WEST SUSSEX COUNTY COUNCIL CONSULTATION

TO:	Arun District Council FAO: Harry Chalk
FROM:	Highways, WSCC
DATE:	11/03/2026
LOCATION:	35 Glamis Street, Bognor Regis, PO21 1DJ
SUBJECT:	BR/5/26/PL New build 2 storey residential townhouse comprising of 1 No 2b/3p and 1 No 3b/5p flats. This application is in CIL Zone 4 (Zero Rated) as other development.
DATE OF SITE VISIT:	N/A
RECOMMENDATION:	Advice

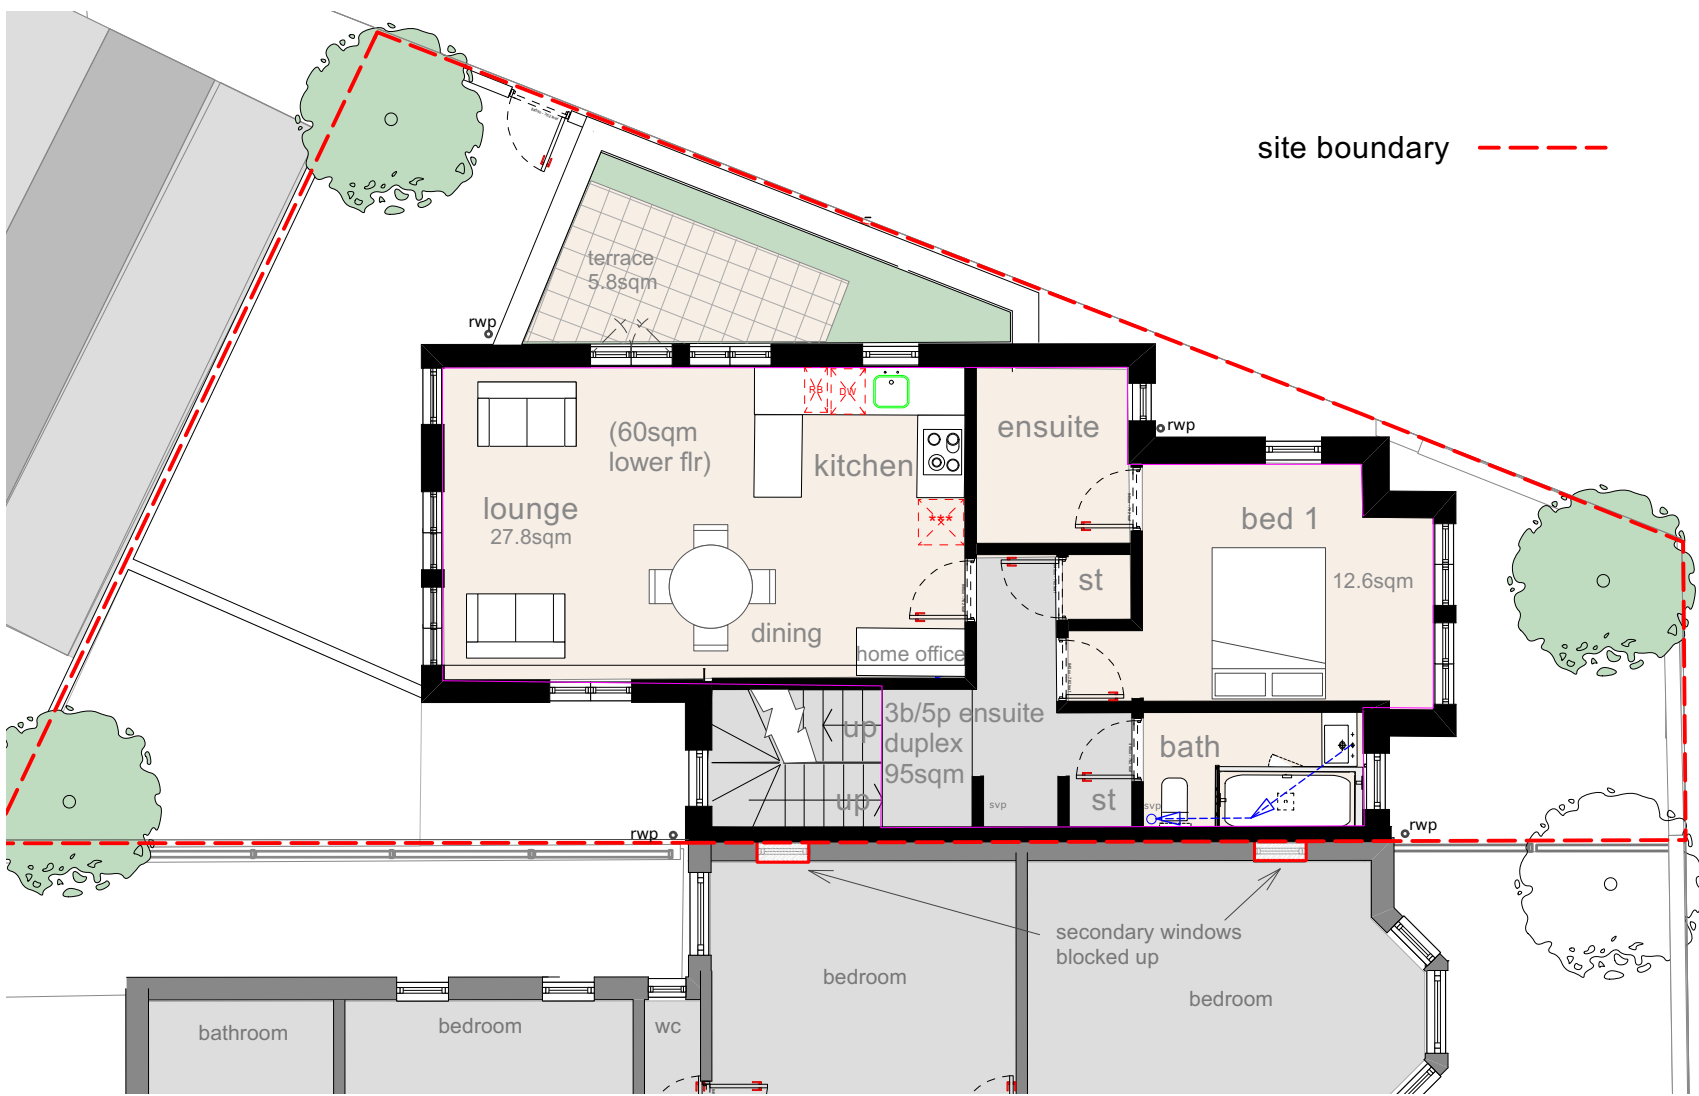
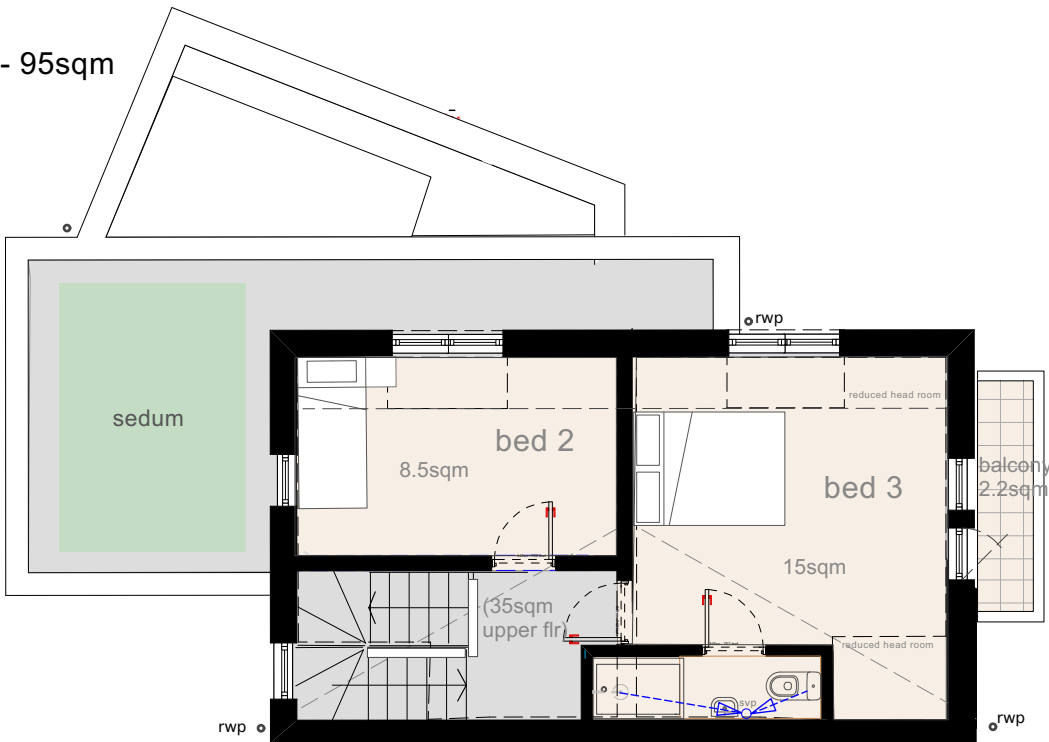
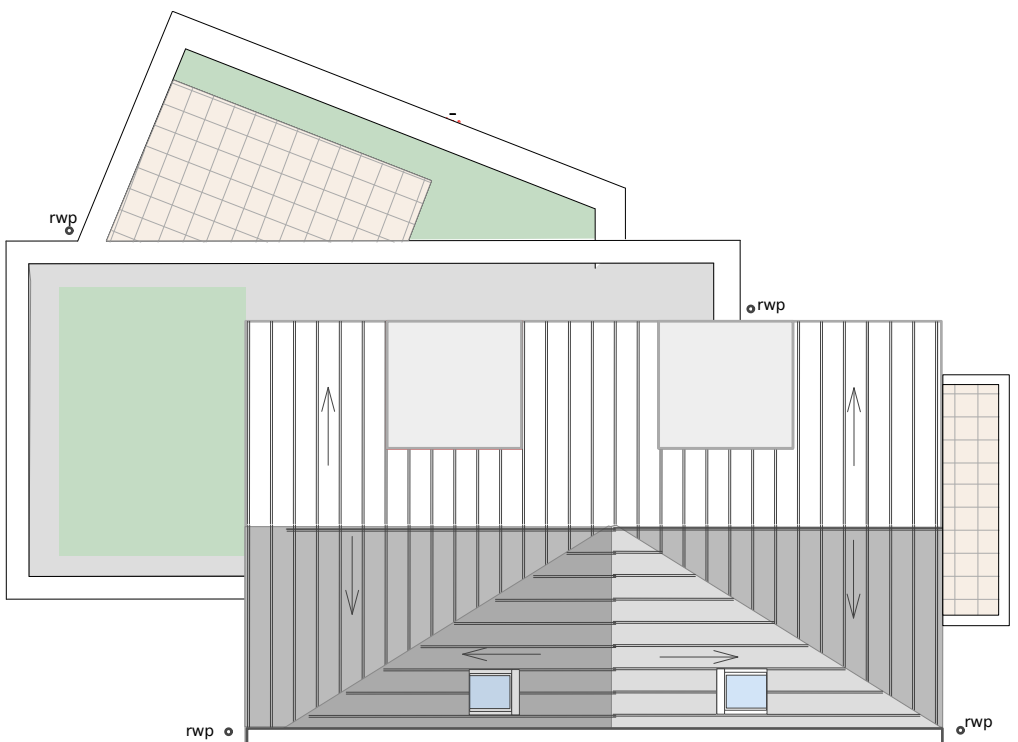
Weight is given to the fact the site is situated in a location considered sustainable, being within walking/cycle distance of local services, amenities and public transport connections - residents need not necessarily rely on a private car for travel. Cycling is a viable option in the area, and the proposals do include cycle parking provision for both dwellings.

Cycle parking

No part of the development shall be first occupied until covered and secure cycle parking spaces have been provided in accordance with plans and details to be submitted to and approved by the Local Planning Authority.
